## ALC

## Technical Note

Appendix 2 - Detailed ALC map

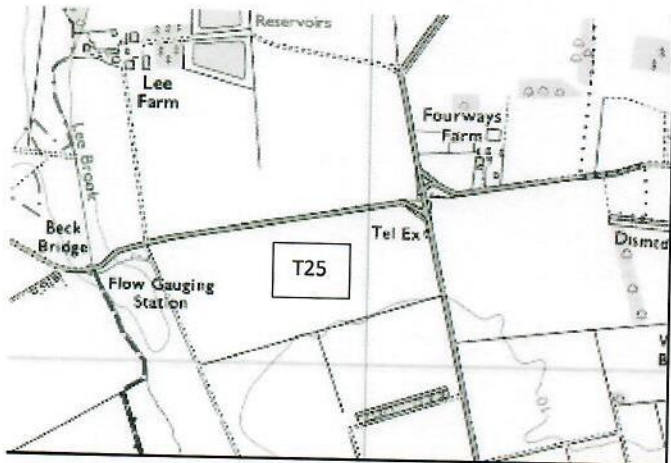
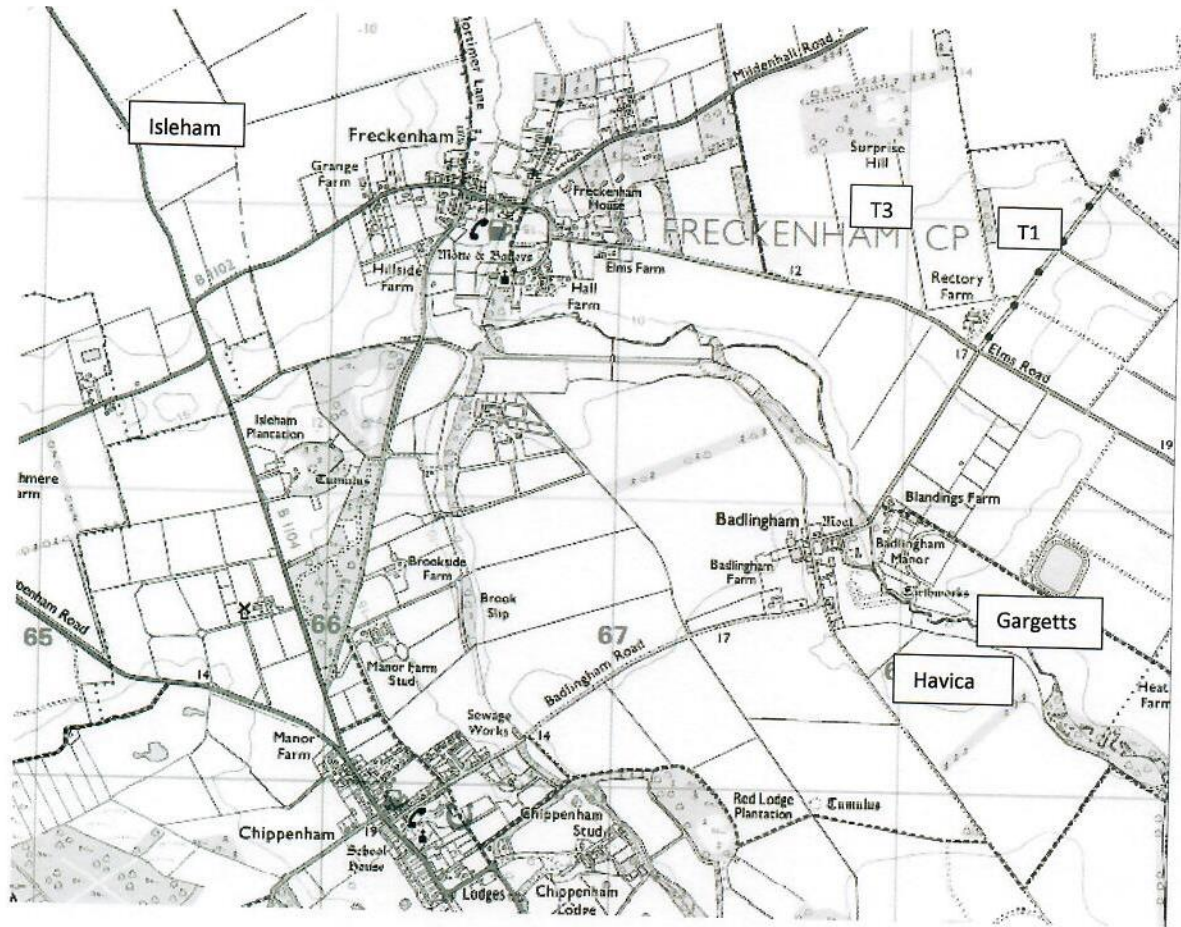
The locations surveyed for SNTS were, in some cases, within metres of the Sunnica site and Grades of 2/3a were found next to soil which was graded as 4 by the applicant. This is further evidence of apparent discrepancy between expected and actual results which emphasises again the need for further investigation.
